**Natural England's response to G5.34 Applicant's response to Natural England's additional guidance on apportioning of seabirds to FFC SPA for Hornsea Project Four [REP5a-018]**

The construction and operation of Hornsea Project Four Offshore Wind Farm, located approximately 69 km from the East Riding of Yorkshire in the Southern North Sea, covering an area of approximately 468 km<sup>2</sup>.

Planning Inspectorate Reference EN010098

27<sup>th</sup> July 2022

Figure 1: Monthly guillemot abundance within Hornsea Four across two-years of baseline survey. Bio-seasons (breeding and non-breeding) are defined by Furness (2015).

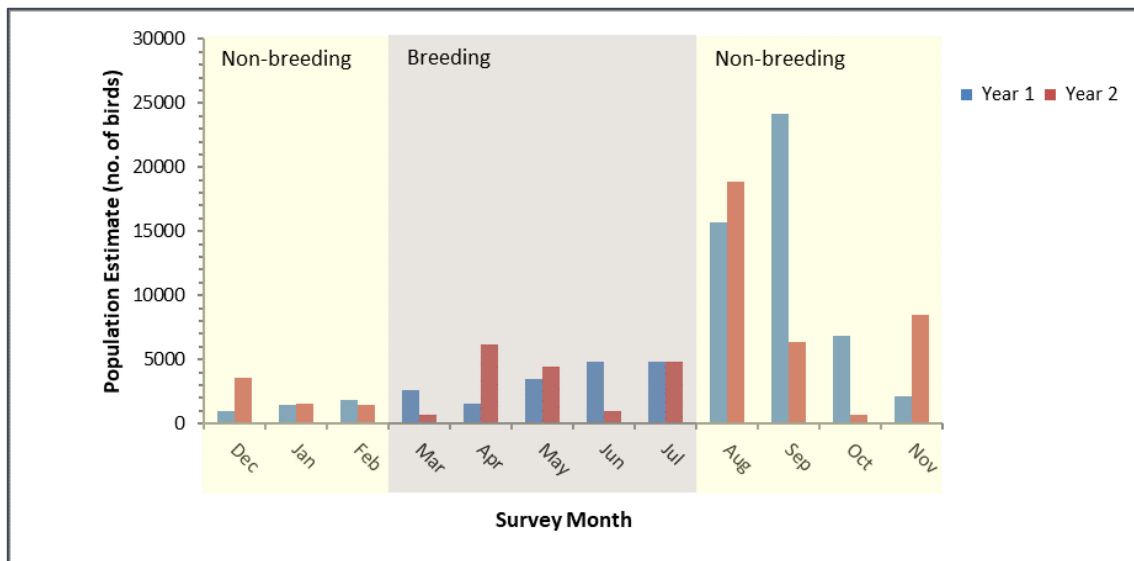
The Applicant’s ‘weighted’ approach to seasonality for guillemot produces total mean peak abundance estimates that are significantly lower than both the generic SNCB approach to displacement assessments, and the Hornsea Four bespoke approach advocated by Natural England. This is shown in Table 2. The Applicant’s approach results in an abundance estimate that is 33,601 individuals smaller than if the Natural England bespoke method is used (approximately half the size), and 16,644 less than would have been produced if SNCB generic guidance was used. The Applicant’s approach therefore substantially reduces the number of guillemot that the displacement assessments for EIA and HRA then utilise. We repeat our advice that this approach is not appropriate.

Season	SNCB generic approach to guidance approach to seasonality	Natural England bespoke method	Applicant’s weighted approach
Breeding (agreed)	9,382	9,382	9,382
Chick rearing/moult	0	36,965	0
Non-breeding	36,965	16,962	20,326
<b>Total annual</b>	<b>46,347</b>	<b>63,309</b>	<b>29,708</b>
